Our Ref: AW/19/20/T

Town & Country Planning Act 1990 (as amended)
Town & Country Planning (Tree Preservation) (England) Regulations 2012
Application for Consent to Carry Out Works to Tree(s) Protected by Tree Preservation Order

Development Reduce overhang on 1 No Horse Chesnut tree by 3m. Reduce 1 No. Oak tree by 2.5m. Reduce height by 3m and laterals by 2m to 1 No. Ash tree.
Location 6 Cedar Close Aldwick

6 CEDAR CLOSE

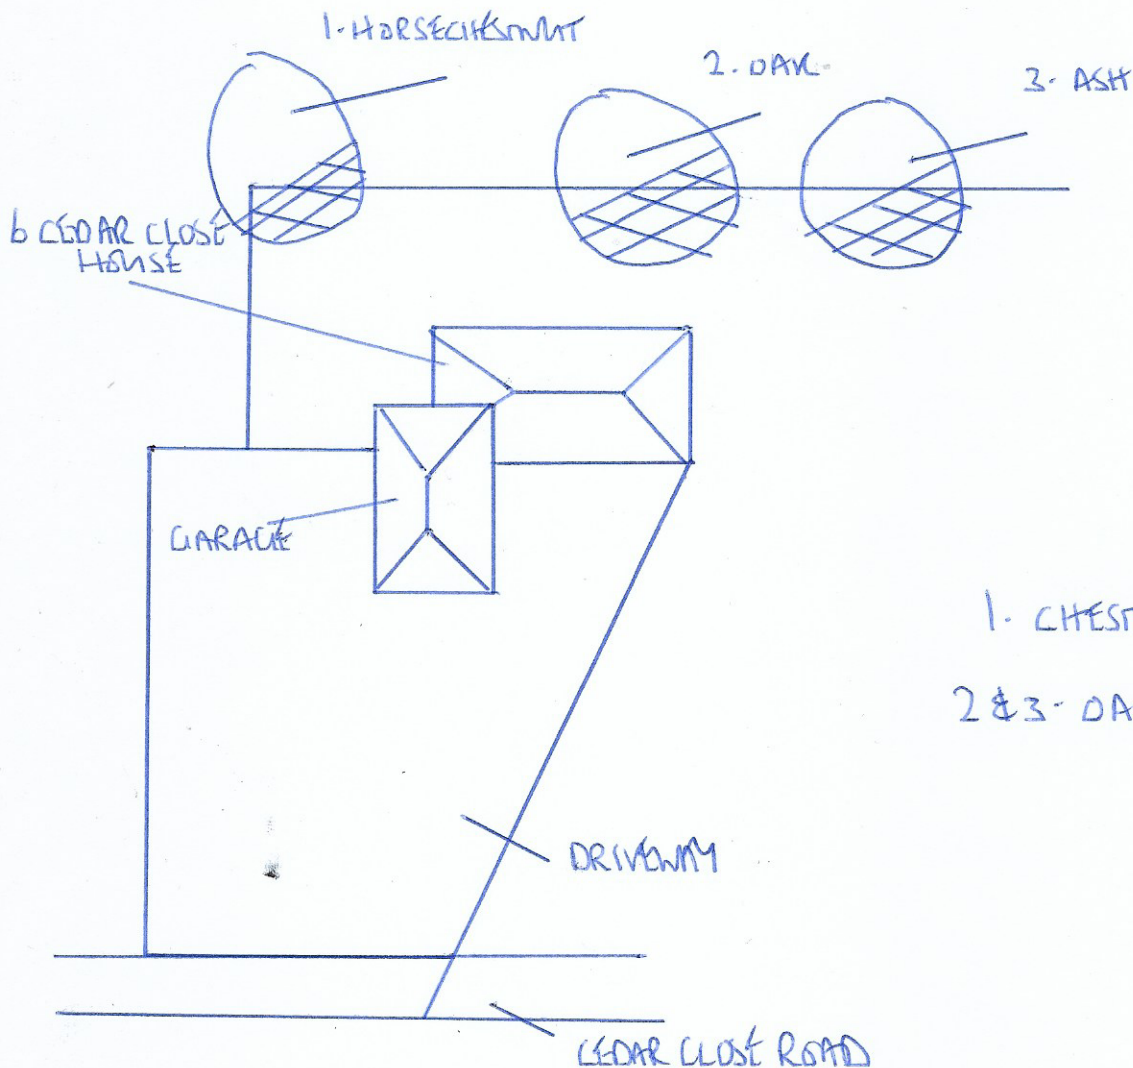
Please provide the measurement of the overhang to 1 No. Horse Chesnut tree after pruning.

Please provide the measurements in metres of the height and spread of 1 No. Oak tree and 1 No. Ash tree after pruning.
